MONA OFFSHORE WIND PROJECT

Mona Examination Progress Tracker

Document Reference: S_PD_4 **F03** [F04](#)

Document Number: MOCNS-J3303-JVW-10219

Figure 1.5: Surface watercourses and NRW flood zones within the Mona hydrology and flood risk study area (sheet 3).

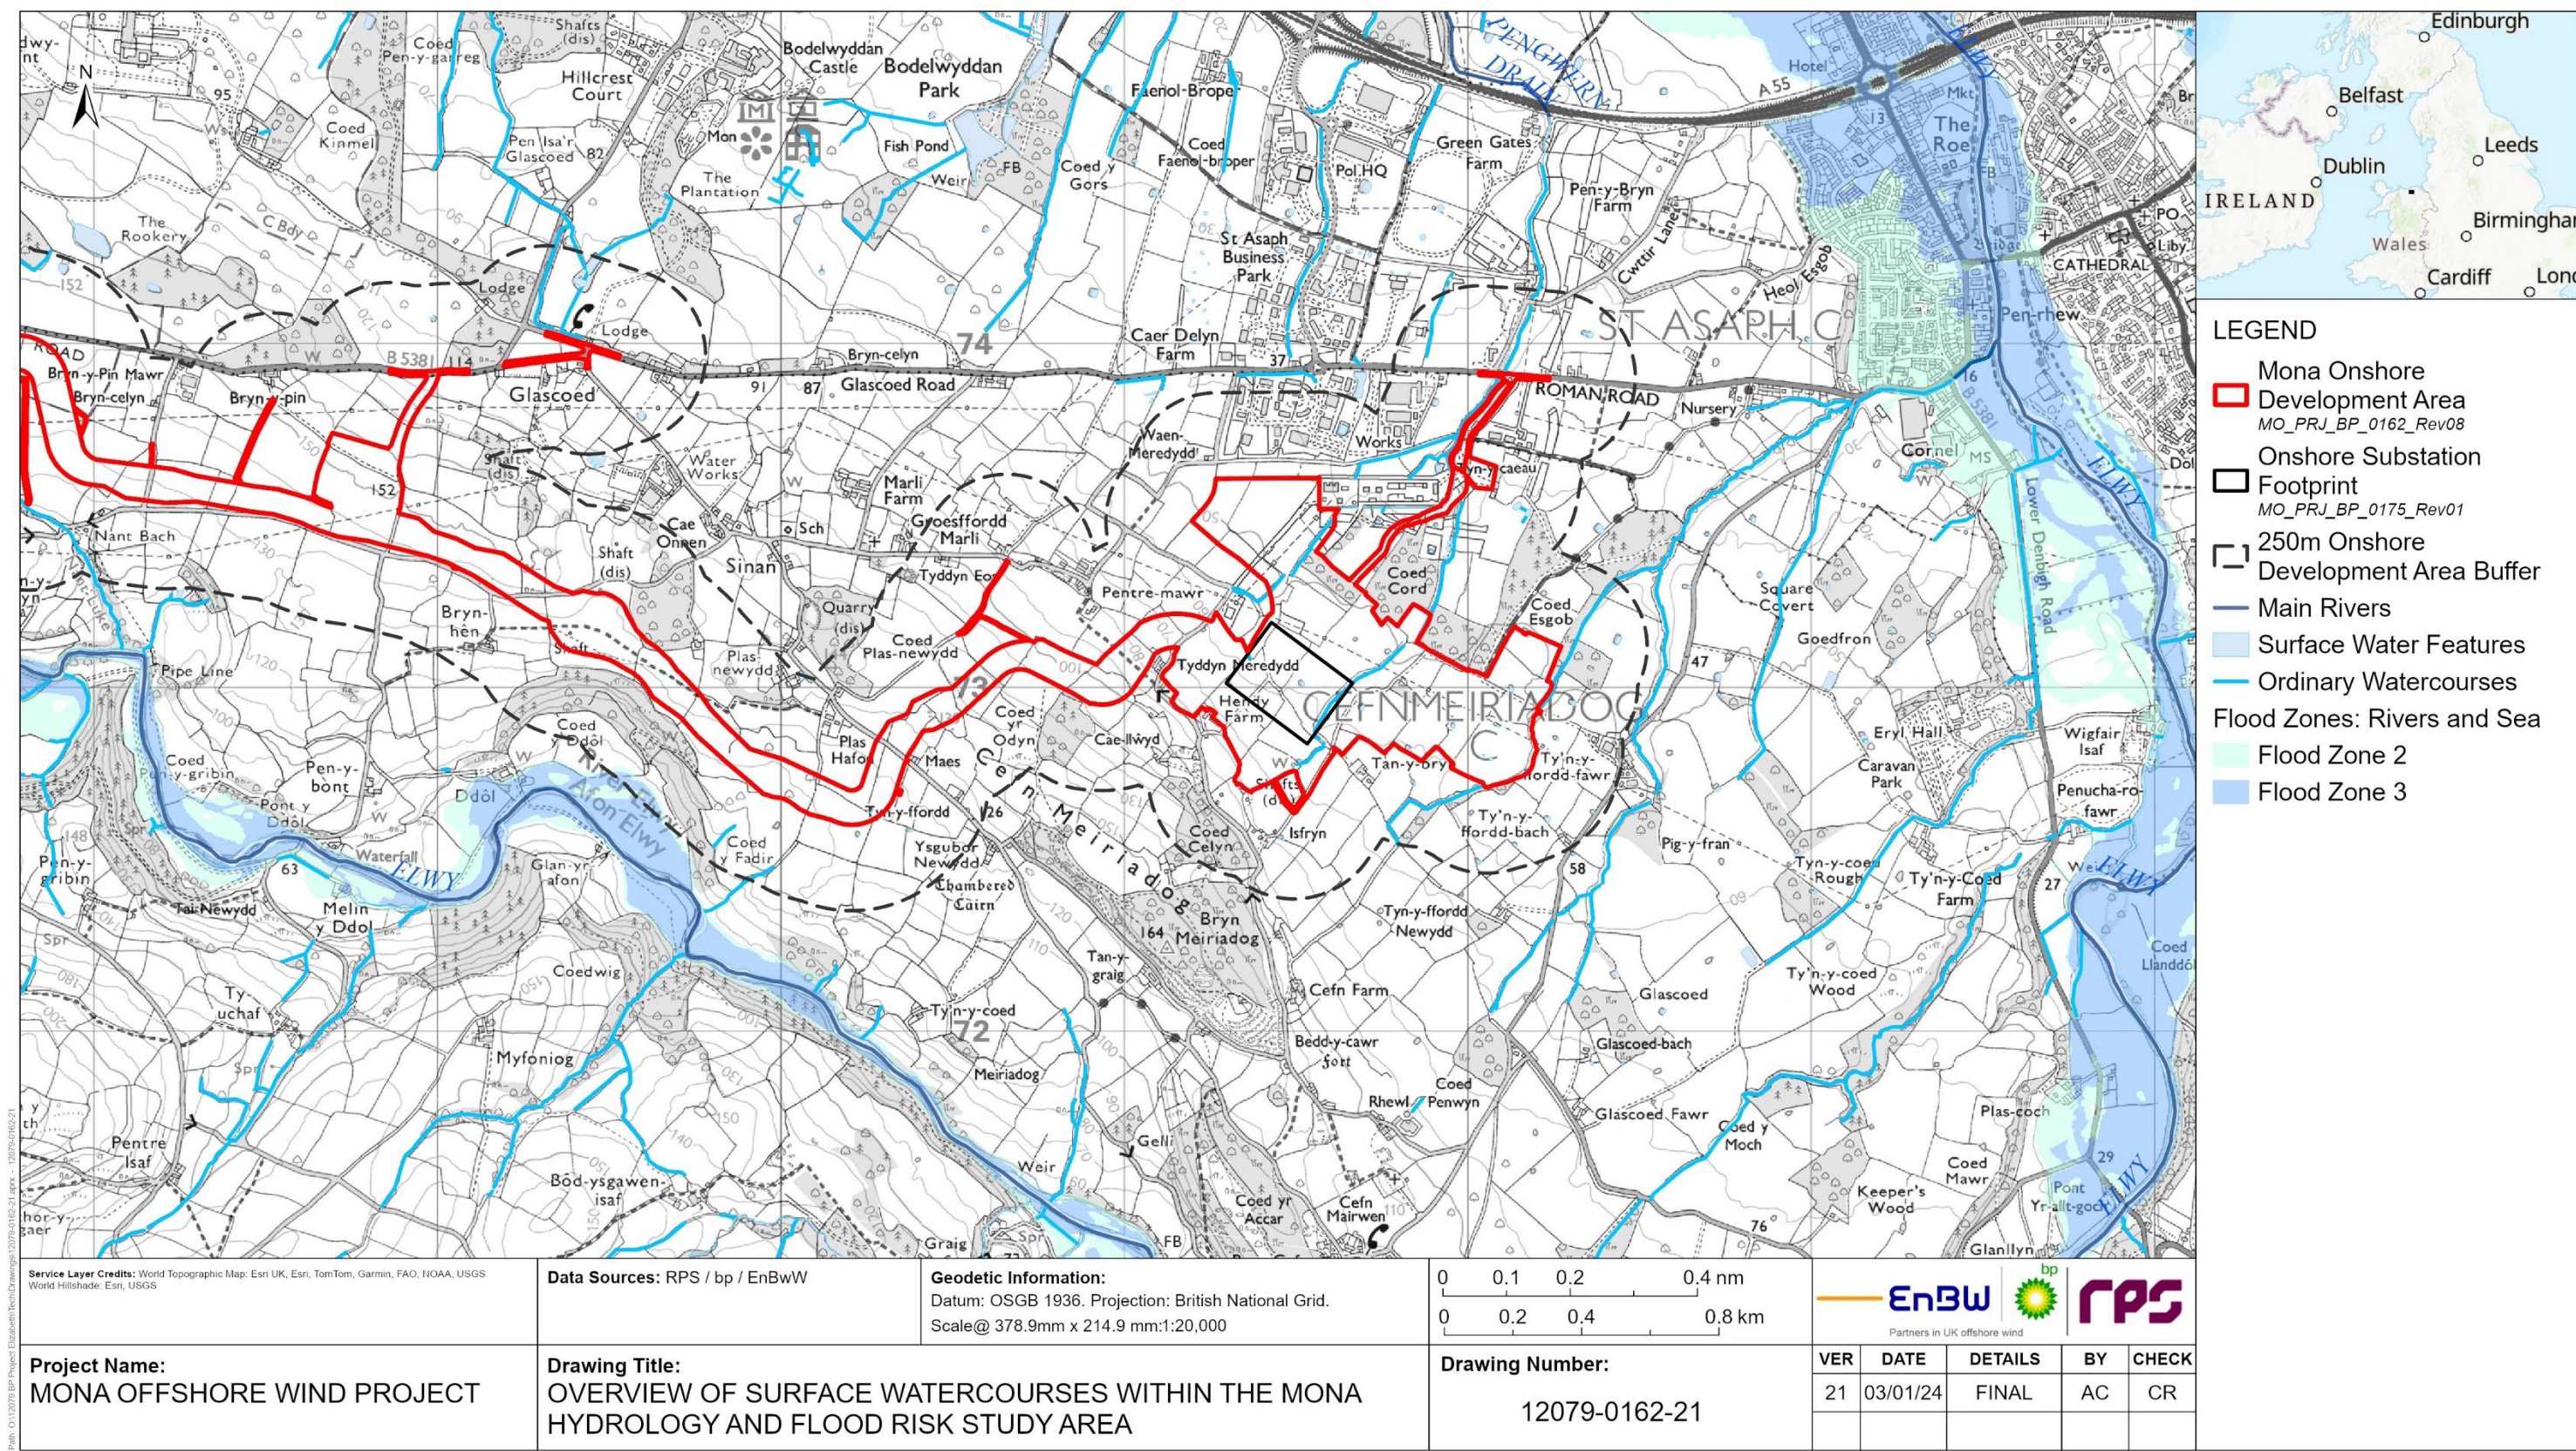
Interested Party	Principle Issues	Progress
	<p>Surface watercourses and crossings – In their relevant representation (RR-011), NRW requested updates to figures within Volume 7, Annex 2.2: Surface watercourses and NRW Flood Zones to provide clarity.</p>	<p>Green: The Applicant has responded to relevant representations (PDA-008, paragraph RR-011.138).</p> <p>NRW have confirmed through their Written Representation (REP1-056) that this response has addressed their concerns, therefore the Applicant believes this issue has now been resolved.</p> <p>This is captured in the SoCG between the Applicant and NRW (REP1-026, paragraphs NRW.HFR.01 to NRW.HFR.10).</p>
<p>CCBC</p>	<p>The Local Impact Report (REP1-049) requests further baseline data to be provided in relation to fluvial geomorphology.</p>	<p>AmberGreen: The Applicant has responded to the Local Impact Report (REP2-092, paragraphs REP1-049.72 to REP1-049.85).</p> <p>The Applicant is progressing a SoCG with CCBC (REP3-061) and the parties are in discussion regarding the crossing of watercourses, with a topic specific A meeting taking place was held on 9 October 2024.</p> <p>The Applicant has provided further information on to discuss the geomorphology baseline (S_D4_7) <u>and watercourse crossing methodologies</u> and believes this will resolve NRW's remaining comments and will update the SoCG (REP3-061) <u>subsequently the Applicant submitted a Geomorphology Clarification Note (REP4-040). The SoCG with CCBC has been updated to reflect this to Council's position that this note sufficiently addresses their concerns (S_D3_23 F04).</u></p>
